Community Services Planning Department

RESPONSE TO COMMENTS MAY 26, 2020

Reference: Aspen Ranch Preliminary Plat

SP04
 SHEET 8 OF 22

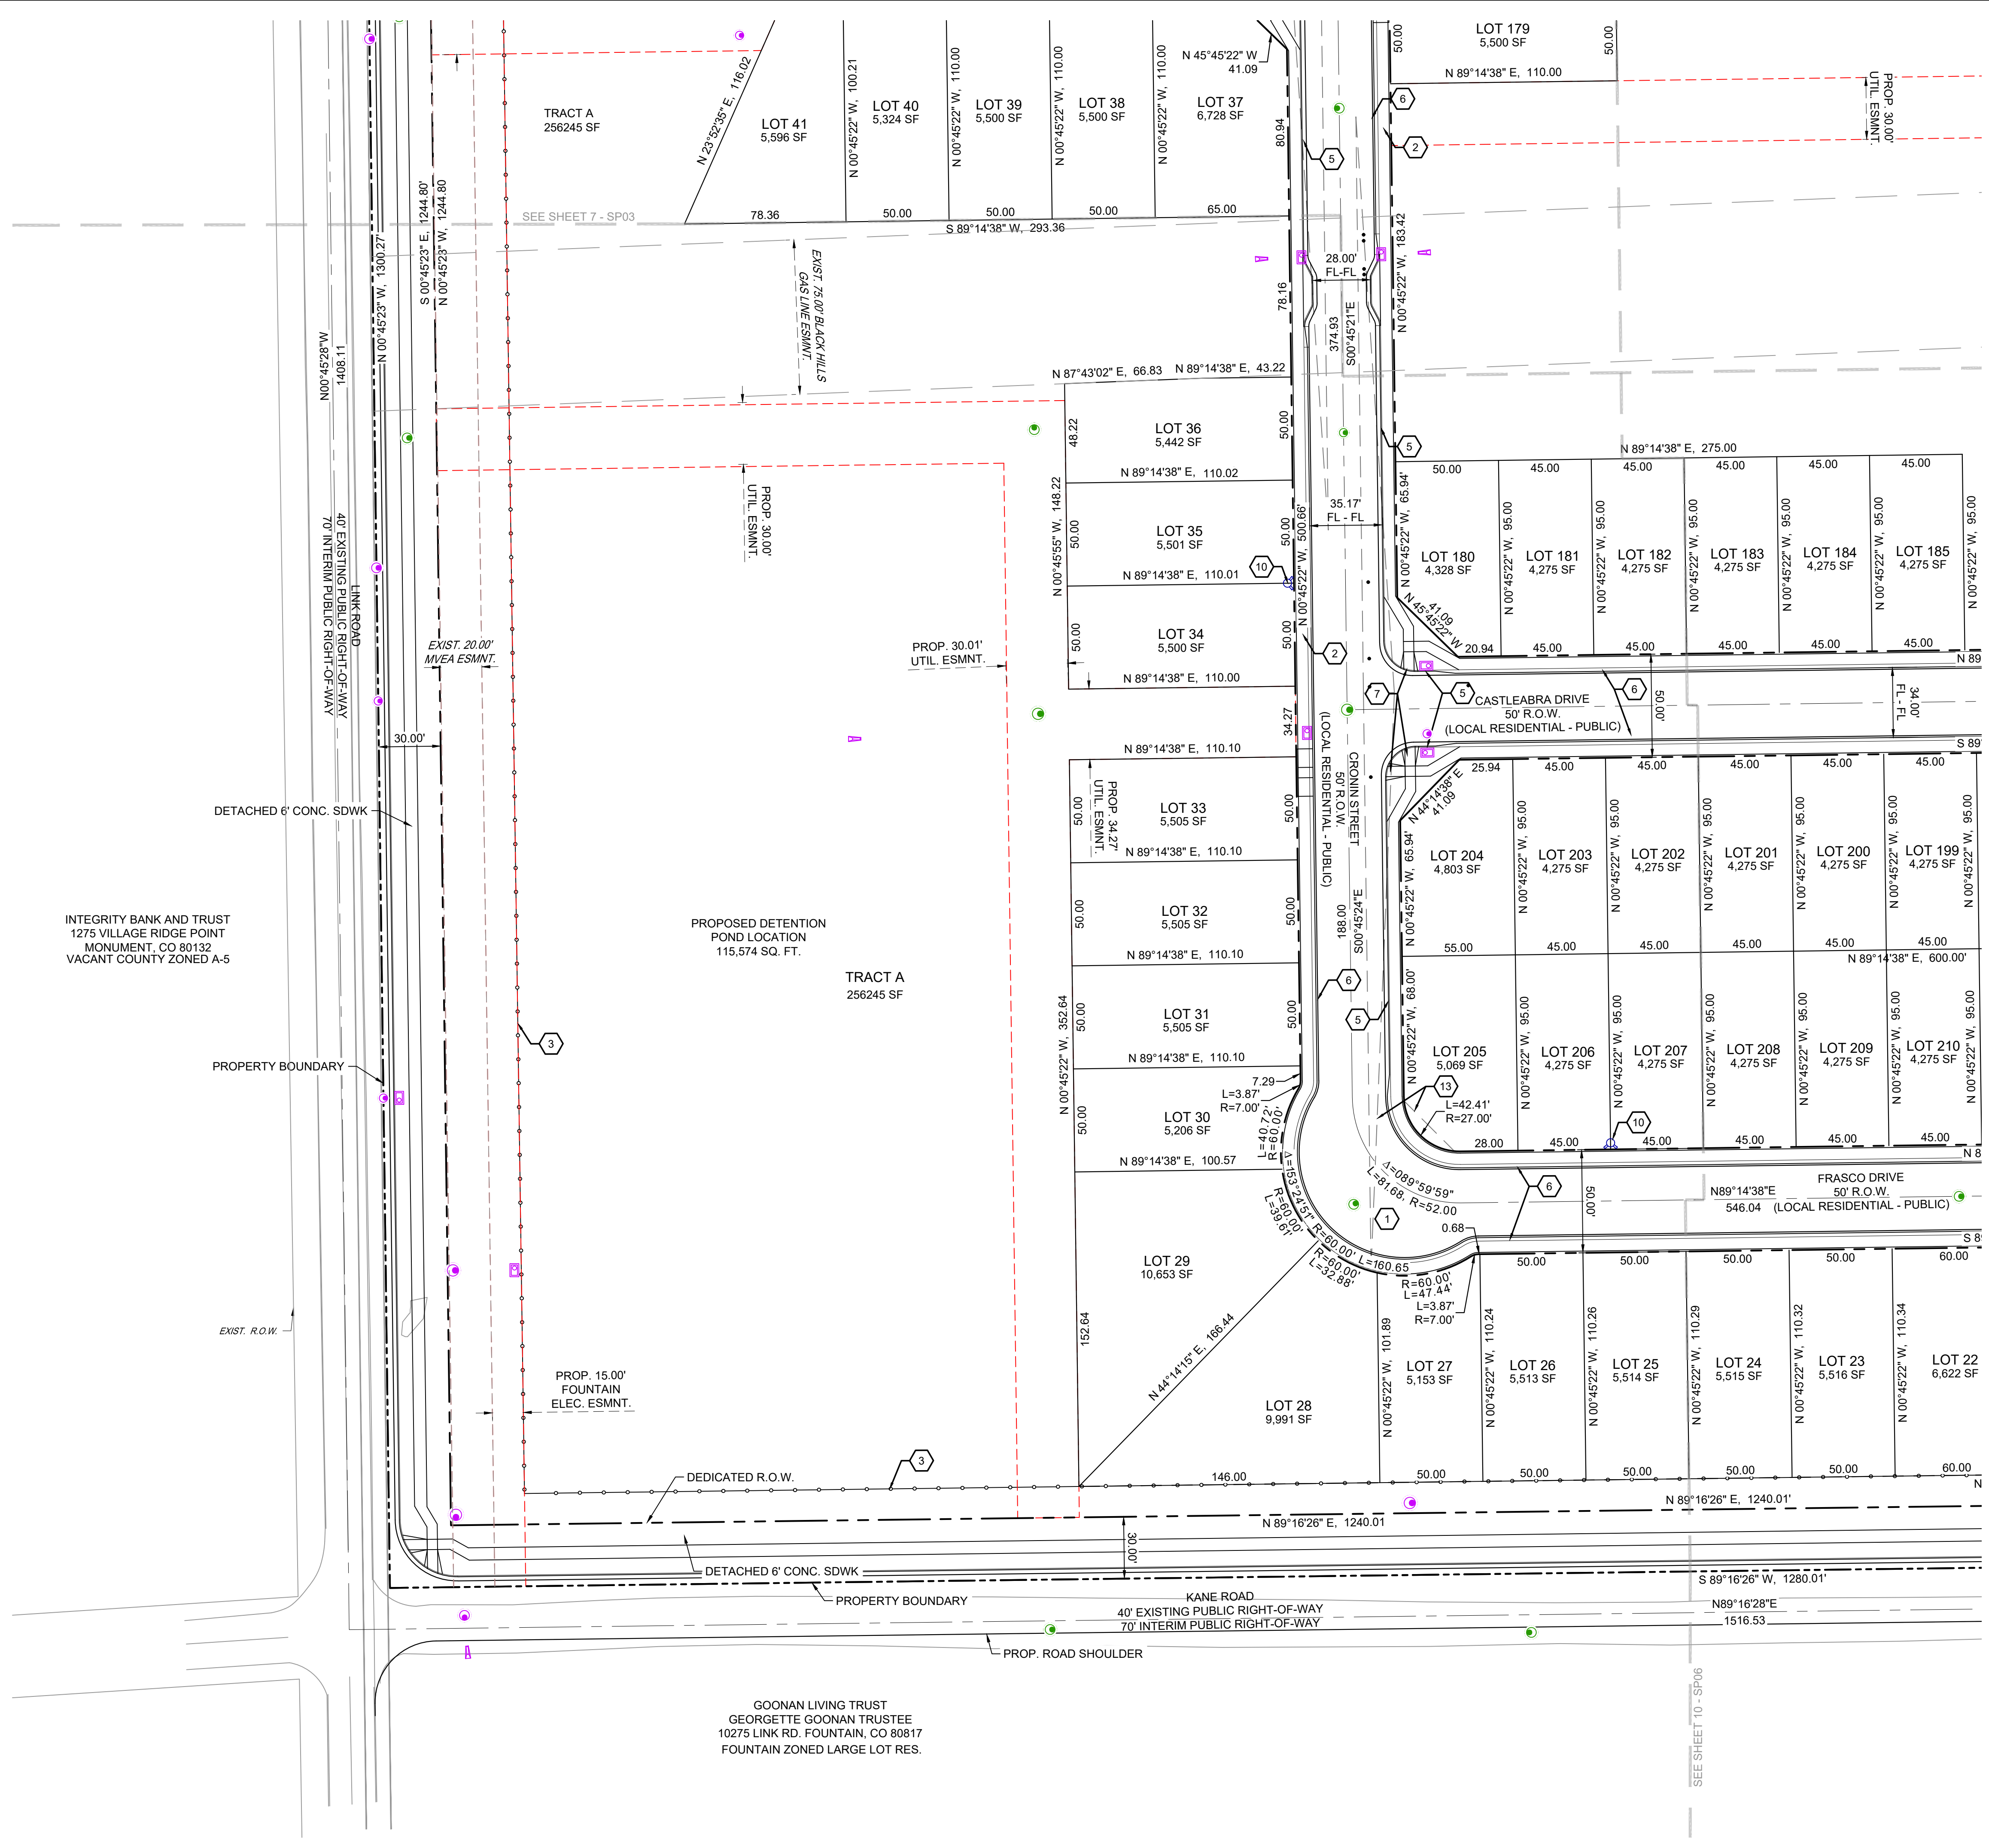
1. Same comment as sheets 6 and 7. **ADDRESSED: PER DOCUMENTATION PROVIDED BY CITY STAFF, THIS ROW HAS BEEN VACATED AND THUS REMOVED FROM ALL DRAWINGS.**

SHEET 10 OF 22

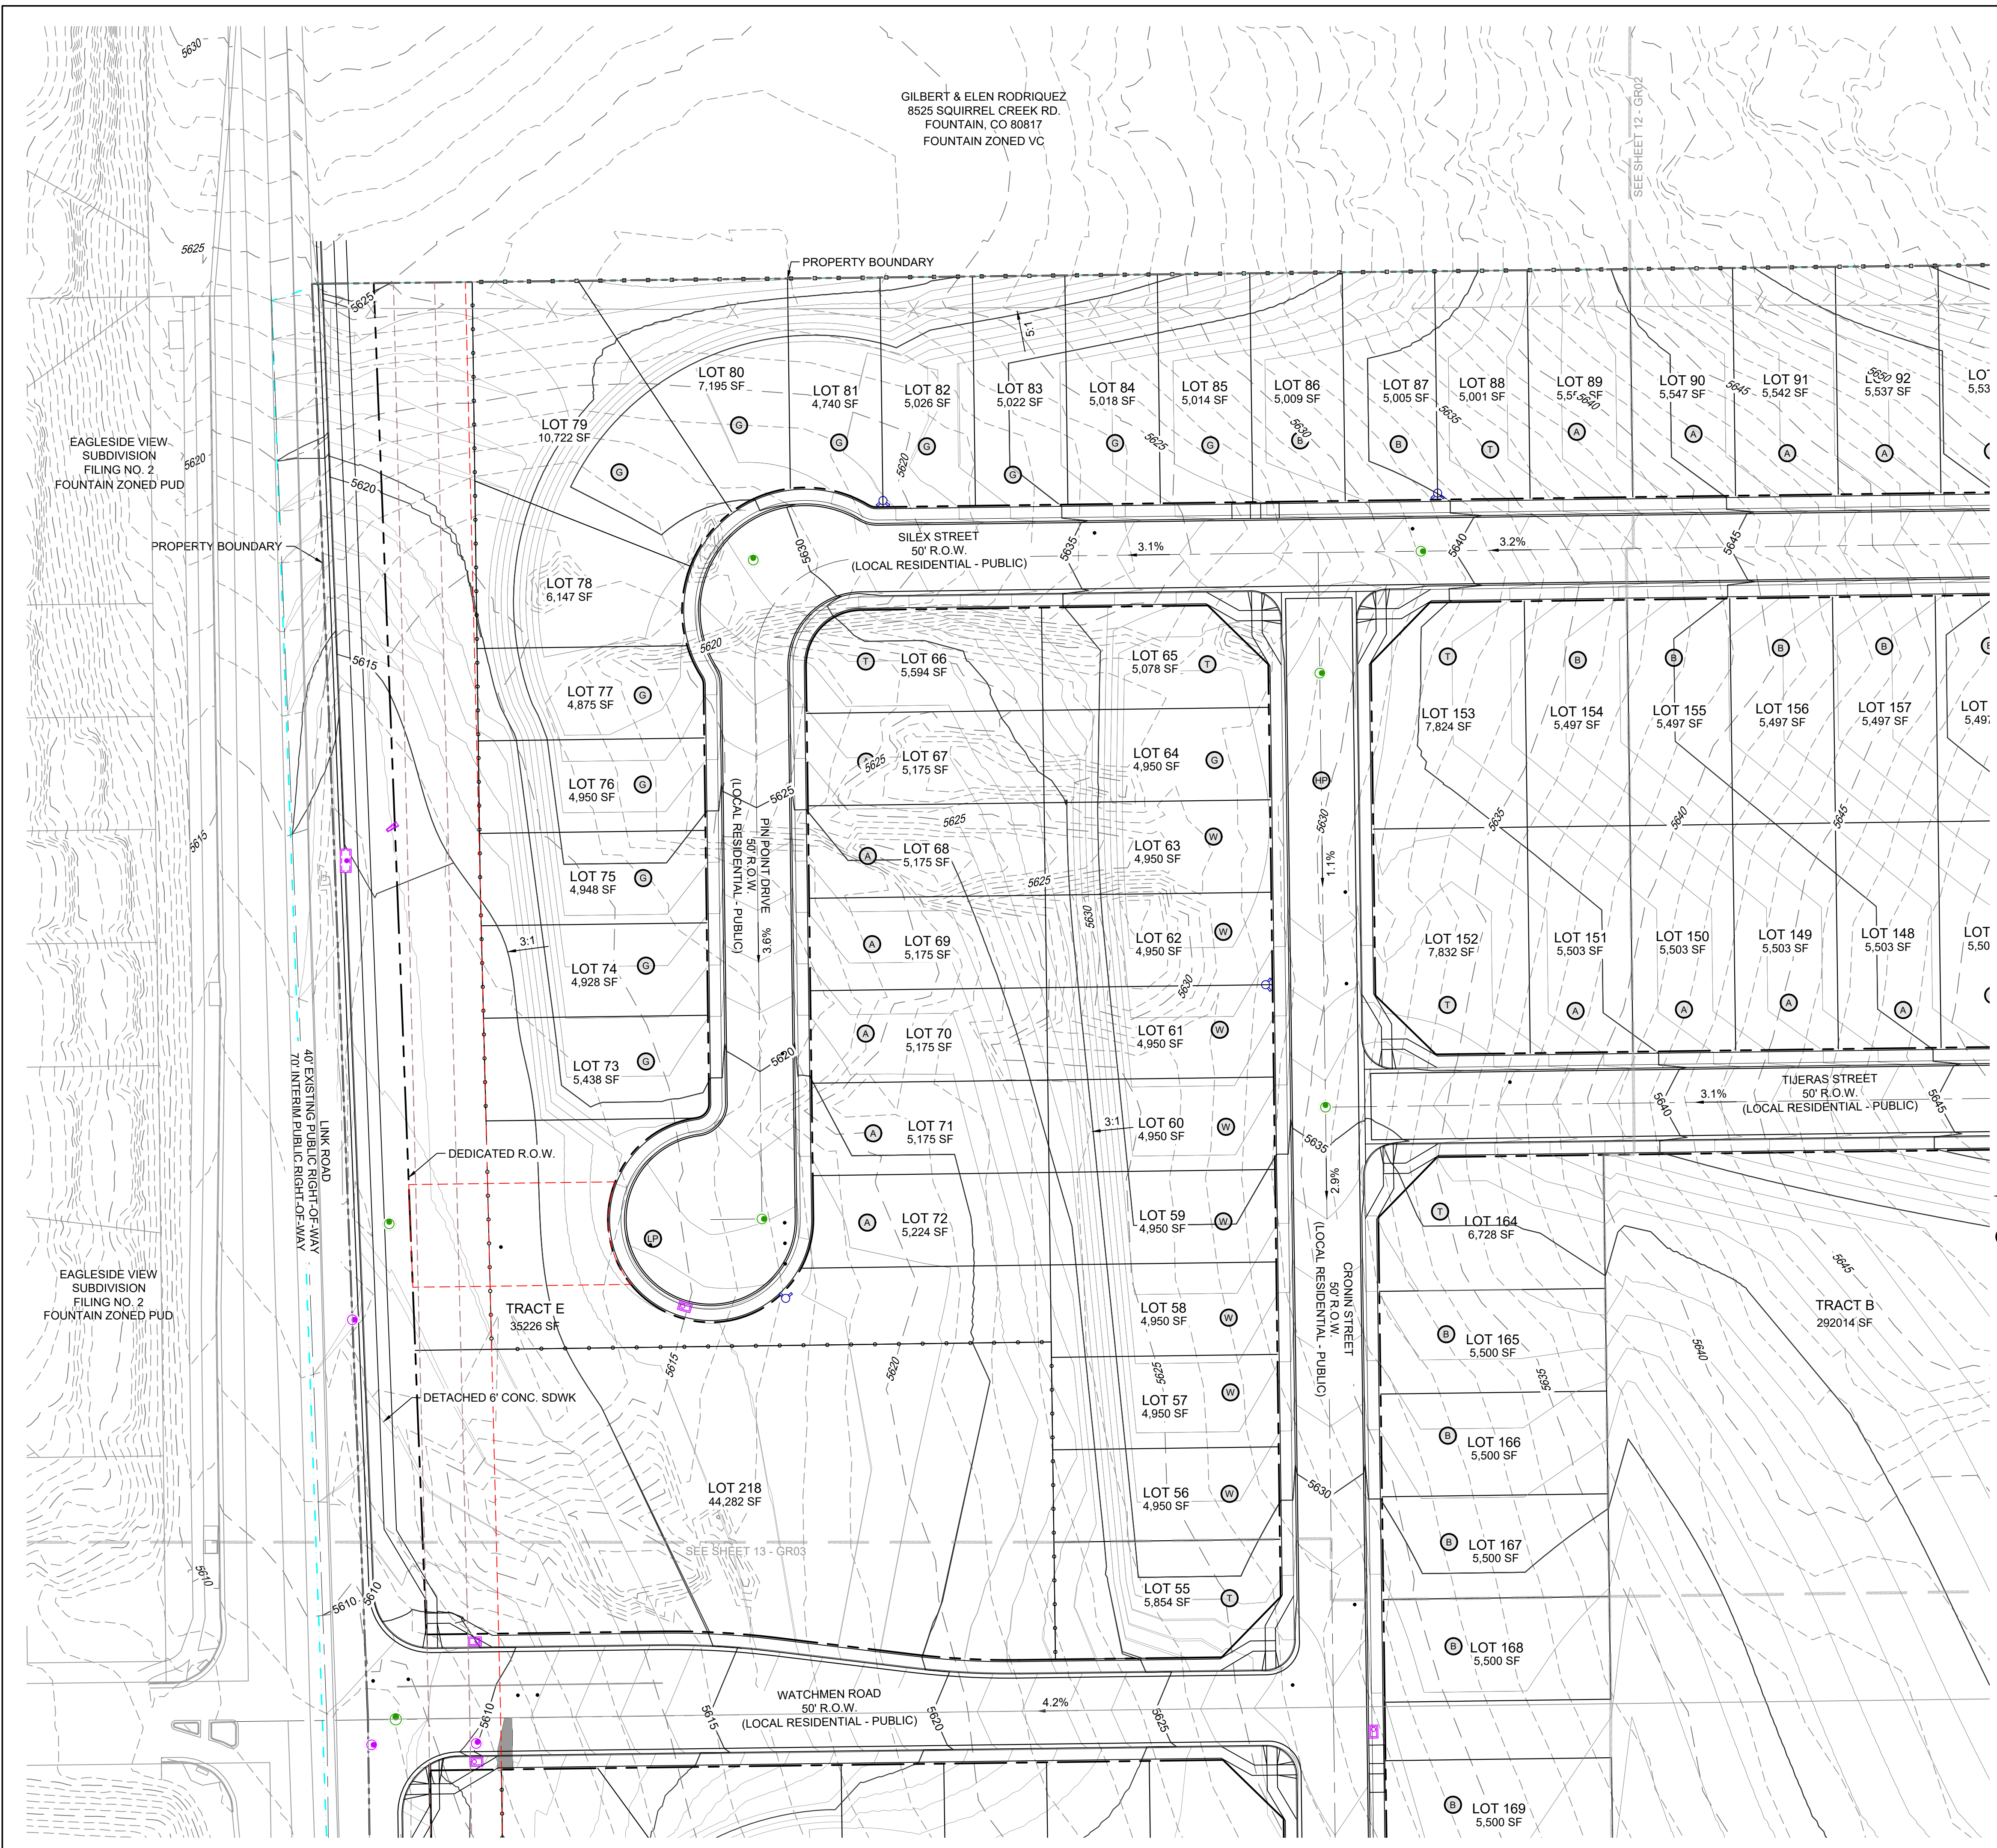
1. The area between the right-of-way for Kane and the lots should be a tract for the landscaping (similar to Tract D along Lots 9-11). **ADDRESSED: TRACT LABEL ADDED.**
2. The area between the right-of-way for Crescent Moon and the lots will also need to be a tract for the landscaping (cannot be an extension of Tract D to the north). **ADDRESSED: TRACT LABEL ADDED.**

GR02
SHEET 12 OF 22
CITY FILE NO.:

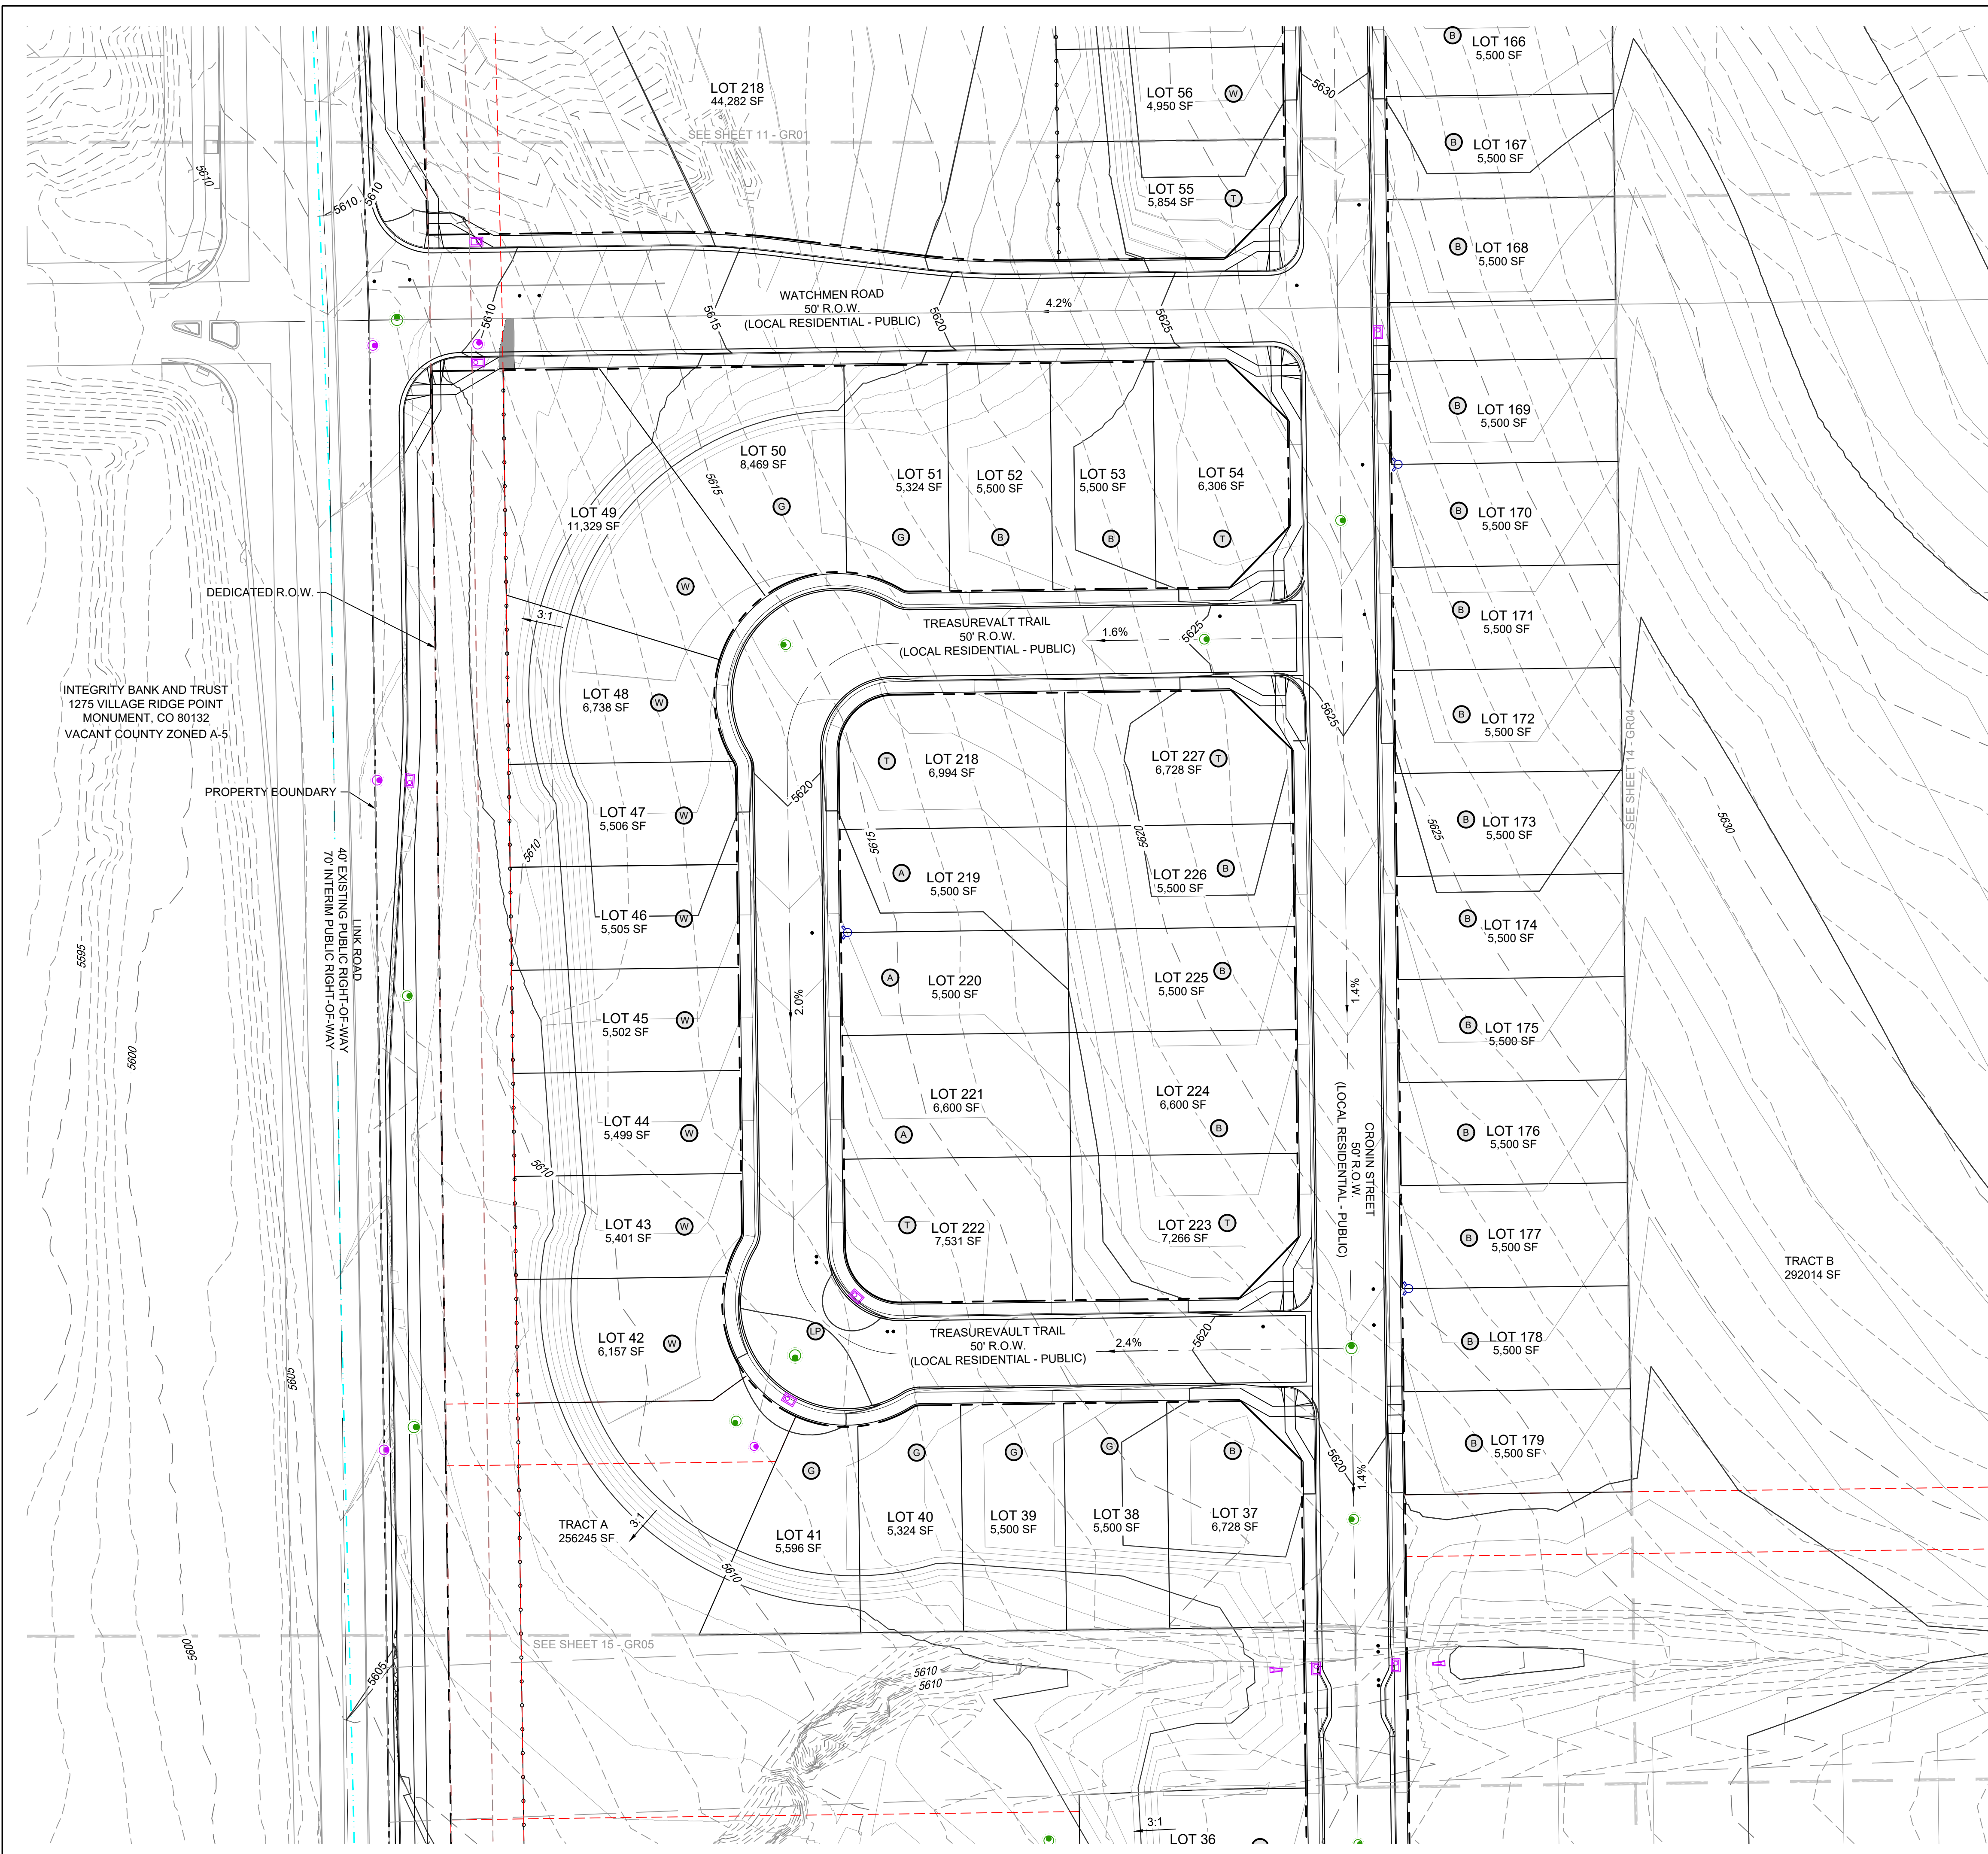
1. Provide a label description of the lot type (A, T, B, W, G). **ADDRESSED: LOT LABEL DESCRIPTIONS AND SECTIONS ADDED TO SHEET DT02.**
